CITY OF PORTLAND, MAINE

Project Name: Residential townhouse - 6 unit condominium
Project ID: 2013-187
Project Address: 133 York Street
CBL: 44-1-29 &31
Applicant: 133 York, LLC, Applicant
Planner: Jean Fraser

On January 28th, 2014 the Portland Planning Board considered and approved a Level III Final Site Plan and Subdivision proposal for the construction of a 6 unit residential building at 133 York Street.

LANDSCAPE PLAN

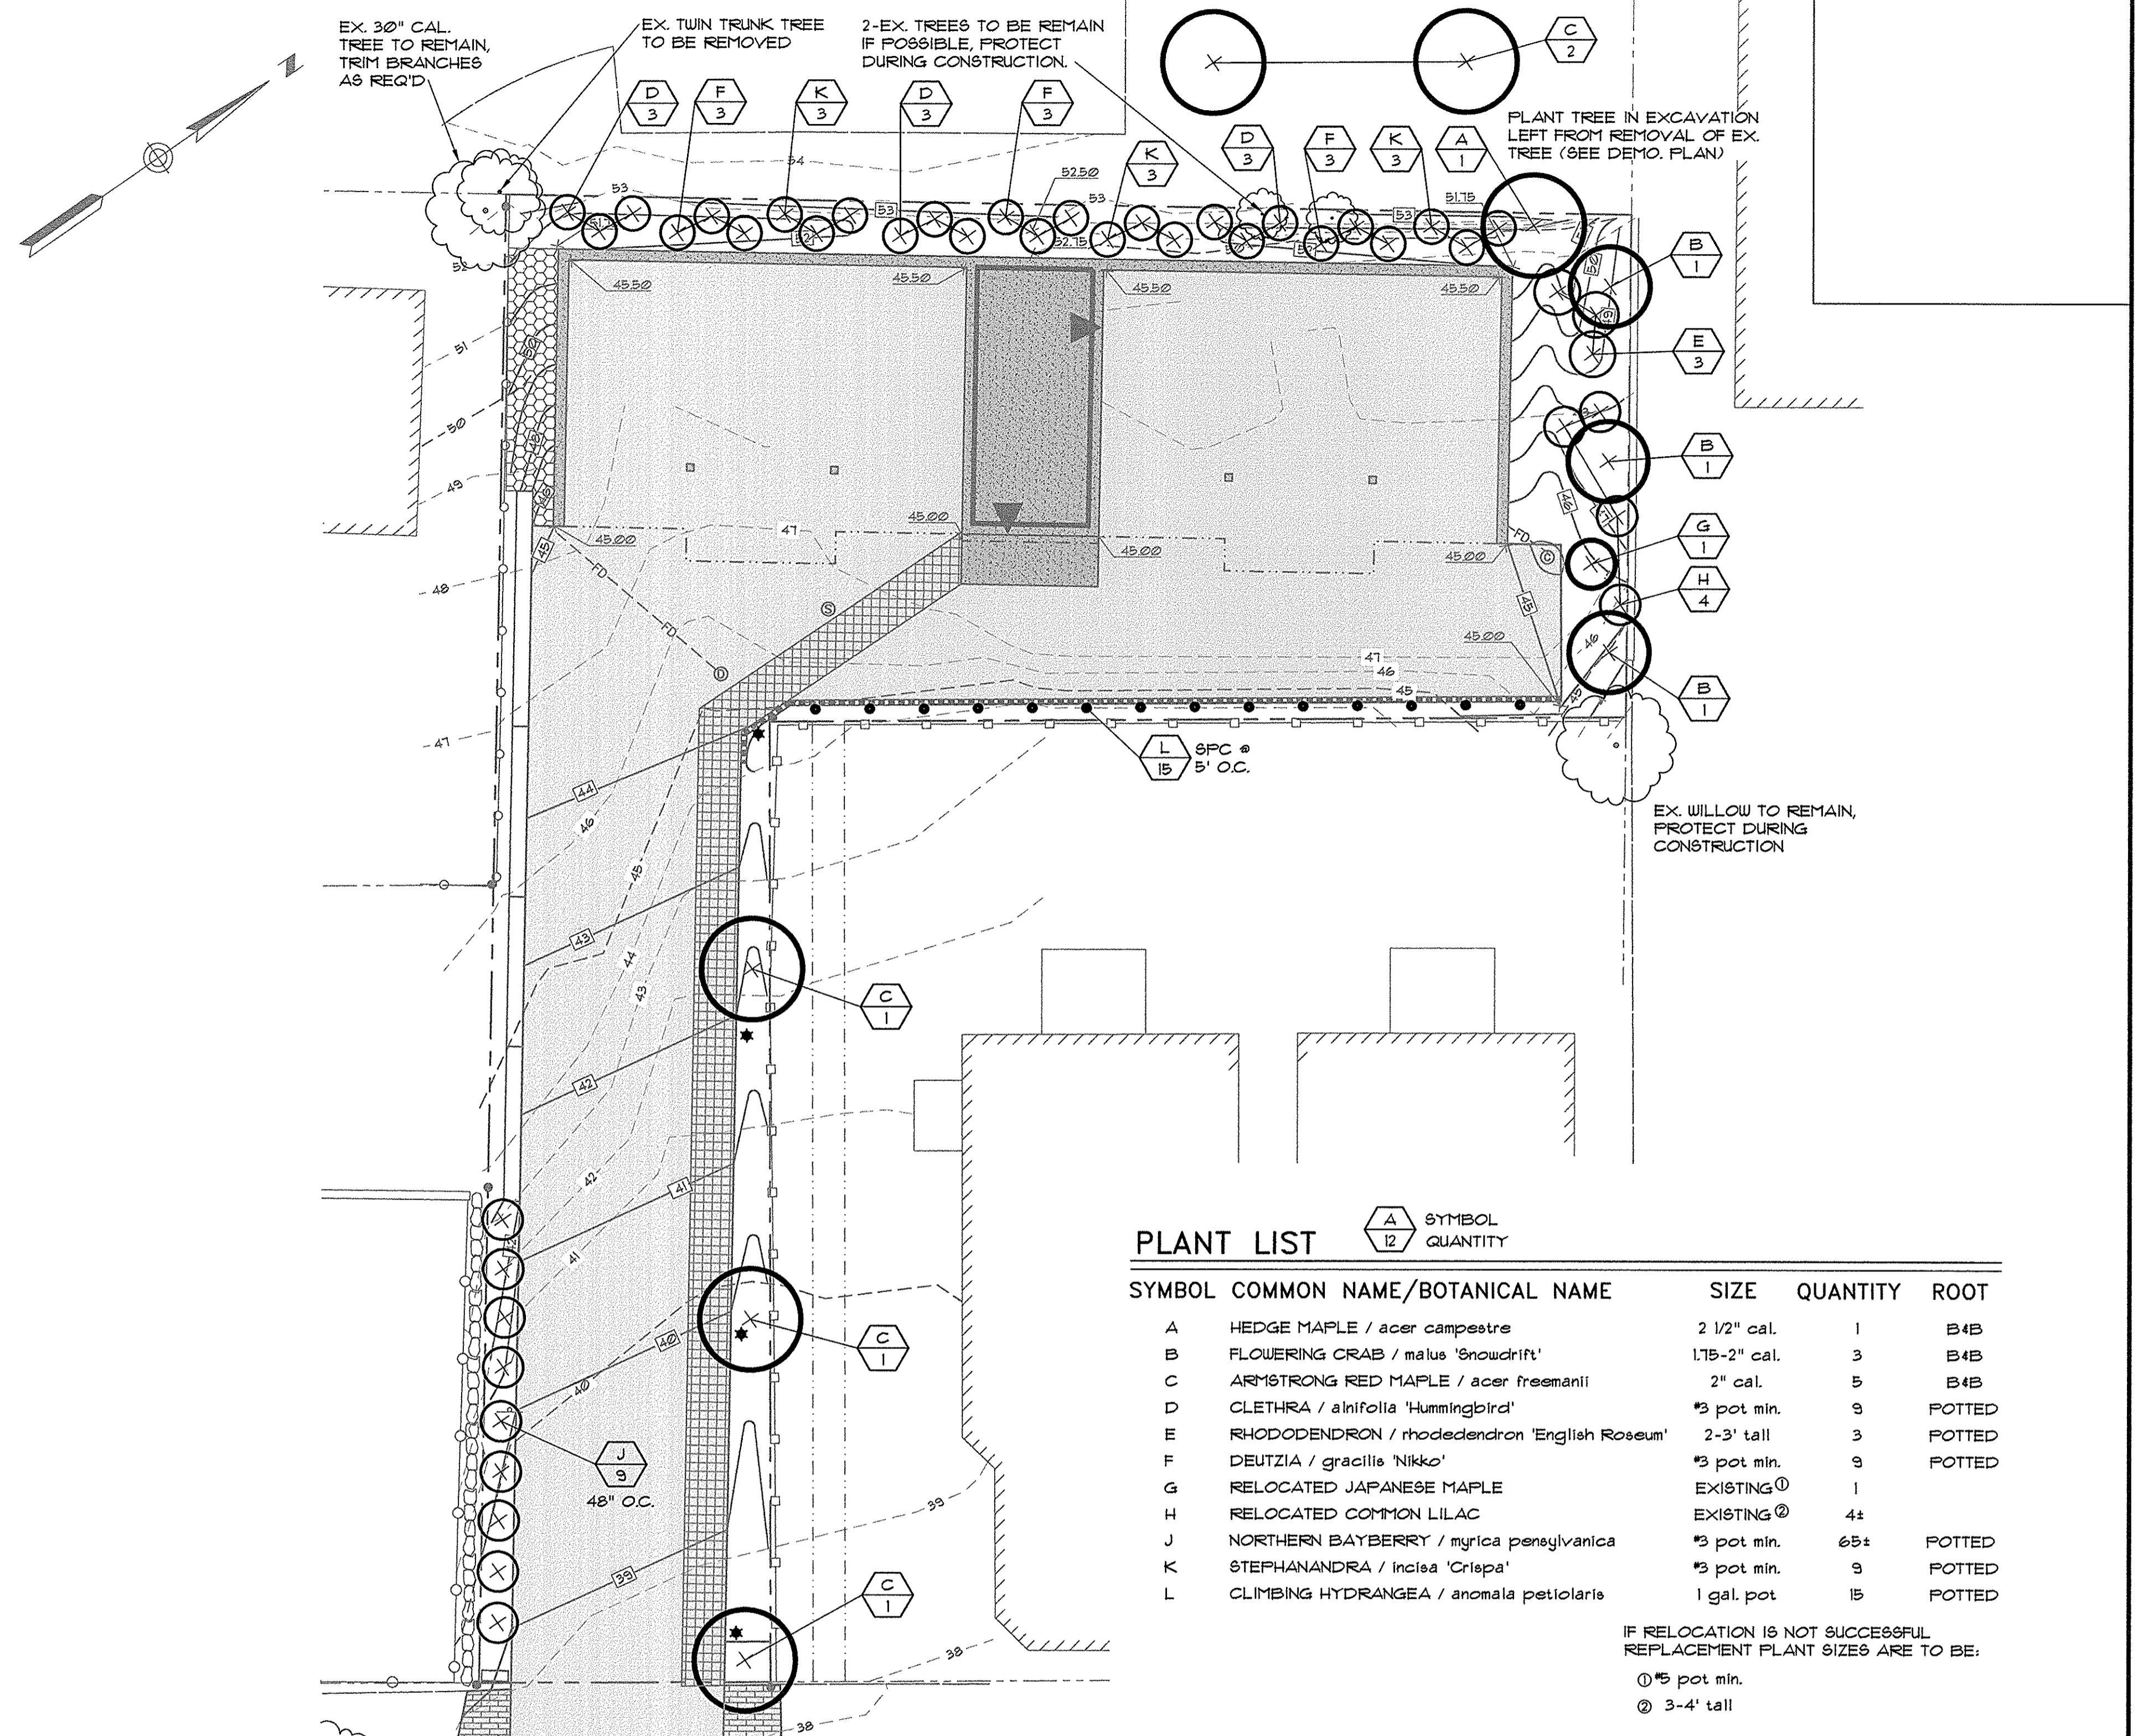
b) landscape plant material: plant sizes - Condition) shrub stock noted as "D" Clethra, "F" Deutzia, "J" Northern Bayberry, "K" Climbing Hydrangea, "L" Stephanandra shall all be #3 pot size minimum and tree sizes should be the following: "B" Flowering Crabapple 1.75-2" caliper, "C" Armstrong Red Maple 2" caliper. Items mentioned as "Existing", "G" Relocated Japanese Maple (#5 pot size), "H" Relocated Lilac (3-4'H) should also have these sizes as replacements if the relocation is not successful. (Too often good intent to save plants through construction are less then successful).

c) Green wall - the proposed project use of a green wall will help screen / buffer the adjacent building. The green wall plant type: Climbing Hydrangea is slow growing, and thus the proposed 1 gallon pot size much to small to be effective for many years... recommendations & condition the green wall plant sizes must be #3 pot & #5 pot sizes alternating minimum to provide a good start for the green wall.

The revised landscape plan addresses earlier comments in regards to buffer along the left side of the driveway and the north side of the project. The project with the conditions mentioned would be acceptable.

The hydrangea size should be #5 gallon pot size minimum, proposed #1 gal size is too small to provide any screening for several years, this buffer is an important feature of the landscape plan. Ideally, every fourth plant could be a #7 size pot to add some height to the planting from the start. Climbing Hydrangea are slow growing.

- ii. That the applicant shall submit a revised Site Plan, Utility Plan and Landscape Plan that address the 1.23.2014 City Arborist comments in respect of planting materials, and include documentation of fencing details on the south and west boundaries and utility modifications on and near the north boundary, for review and approval by the Planning Authority, Department of Public Services and City Arborist prior to the issuance of a building permit; and

SUBDIVISION PLAT, APPROVED BY THE CITY OF PORTLAND PLANNING BOARD

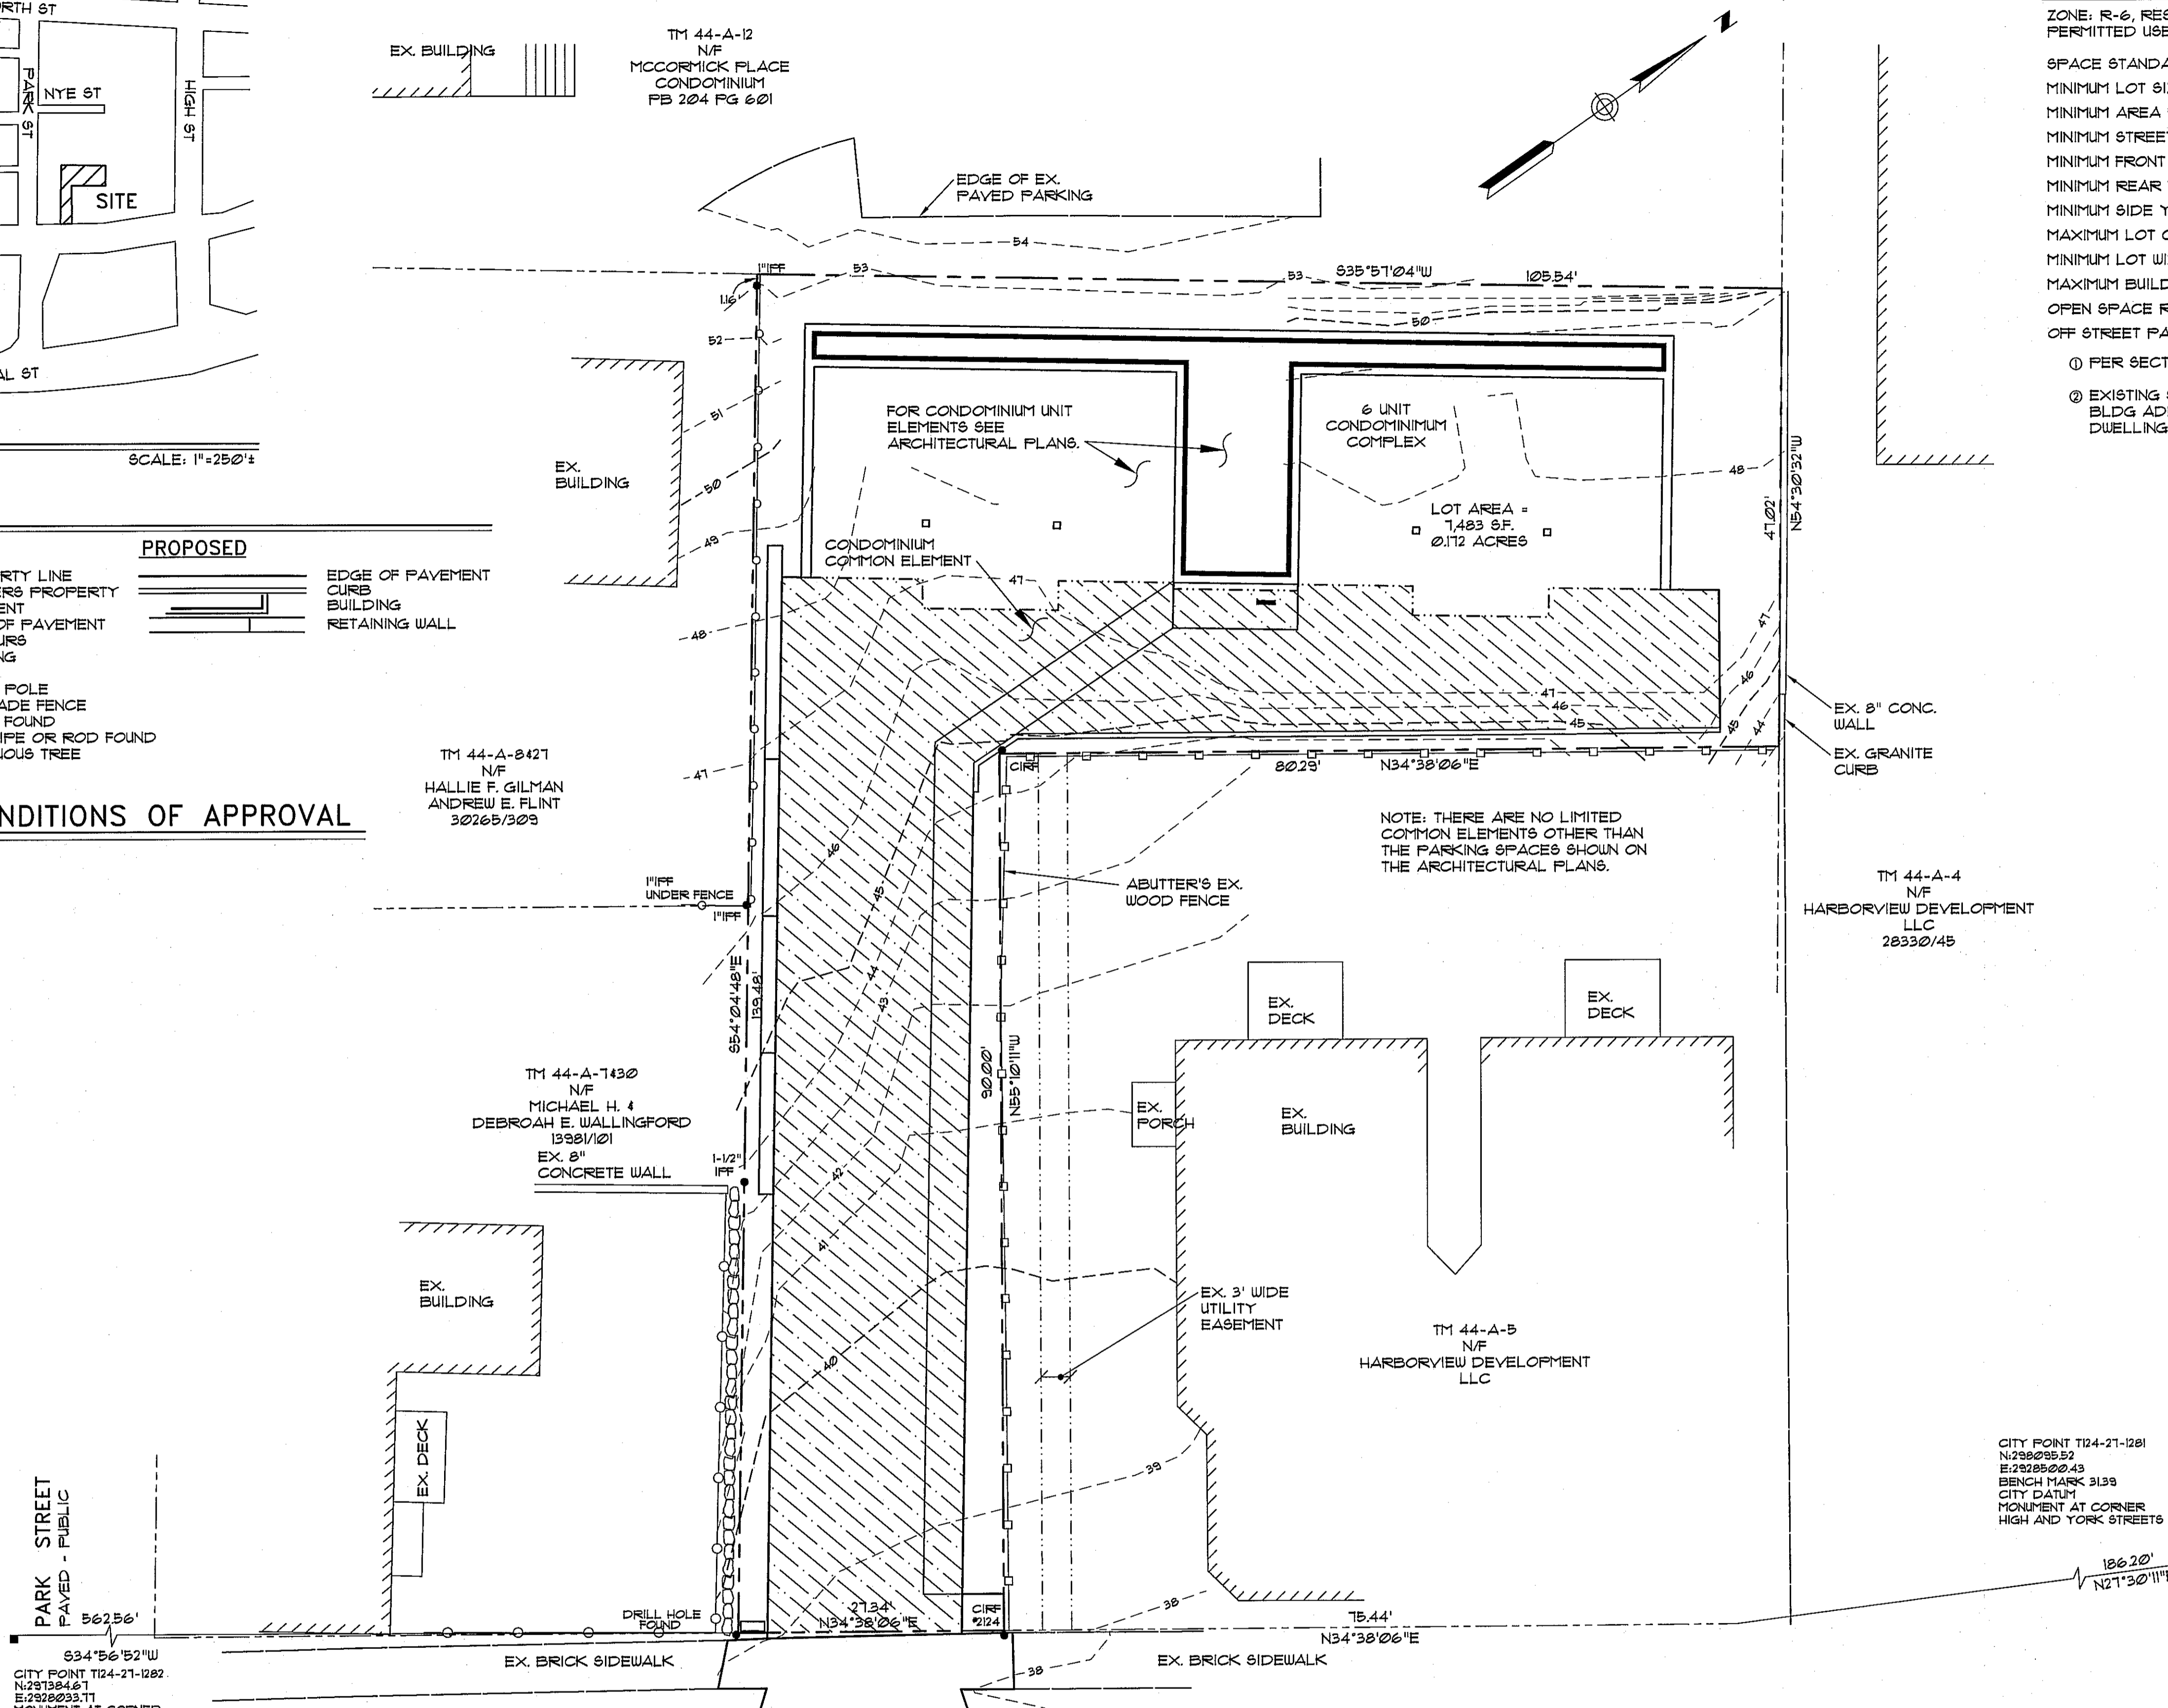
Jean - I agree with your assessment. The Plat and the condo docs for this application are marginal. Although I realize that the practice has, somewhat by necessity, been to make final edits to the plat and condo docs a condition of approval, there is still a requirement that applications for subdivision approval be complete when the go before the Board and that the proposed plat and condo docs contain sufficient detail to allow the Board to make an informed decision. As you say, for this one the plat and in condo docs need to clear in respect to:

snow clearance requirements

Maintenance requirements

Existing utilities

location and purpose of pedestrian walkway between York and the front door

tree preservation measures (ongoing- maybe also during construction?)

location of tree filter and ref stormwater system maintenance (confirming that this is not city and referring to agreement etc)

Agreement re fencing with York Street apartments (see draft attached)

Plat should show street trees

I would also prefer to see the construction easements depicted.

The subdivision plat really needs to inform folks of necessary information on its face. It is not sufficient to be incorporating by reference other sheets when it comes to the essential contents of the plat.

- i. That the Subdivision Plat shall be finalized to the satisfaction of the Planning Authority, Corporation Counsel, and Department of Public Services and include detailed references to easements, snow removal, tree preservation, stormwater system maintenance, relevant conditions, and addressing the comments of the Associate Corporation Counsel dated 1.23.2014; and
